KIRKLEES METROPOLITAN COUNCIL INVESTMENT & REGENERATION SERVICE

Reference No:	2025/70/92933/E
Site Address:	Land off, Marsh Lane, Shepley, Huddersfield, HD8 8AS
Description:	Variation of condition 2 (plans) on previous permission 2024/91202 for erection of eight dwellings with associated access and external works
Recommending Officer:	Elenya Jackson

DECISION – VARIATION OF CONDITION APPROVED

GROUND FLOOR SETTING OUT PLAN.
1:50

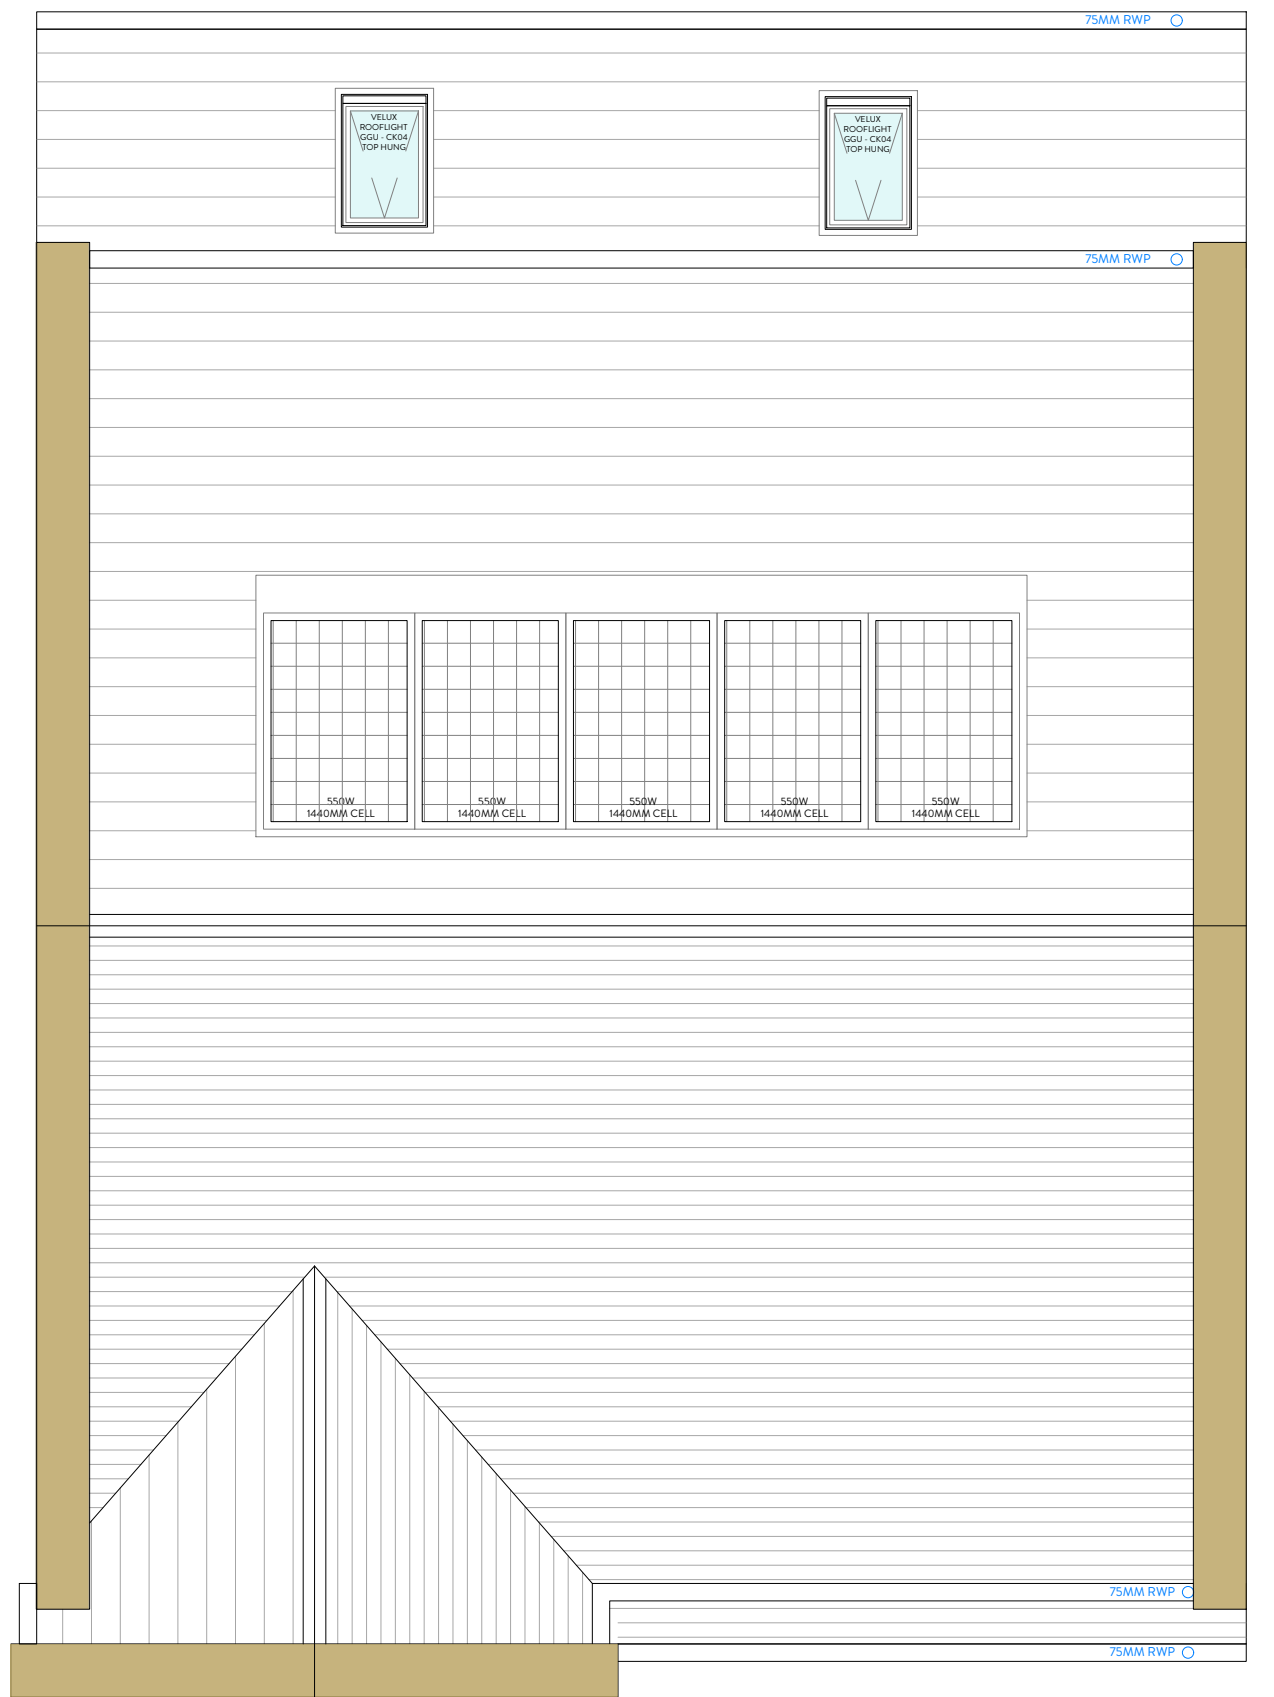
Plot 1

- Addition of a canopy to front elevation
- Addition of window on southern elevation to serve bathroom
- Removal of window at ground floor level on eastern elevation
- Changing internal configuration
- Altering ground floor side door to northern elevation
- Alteration to solar panel layout
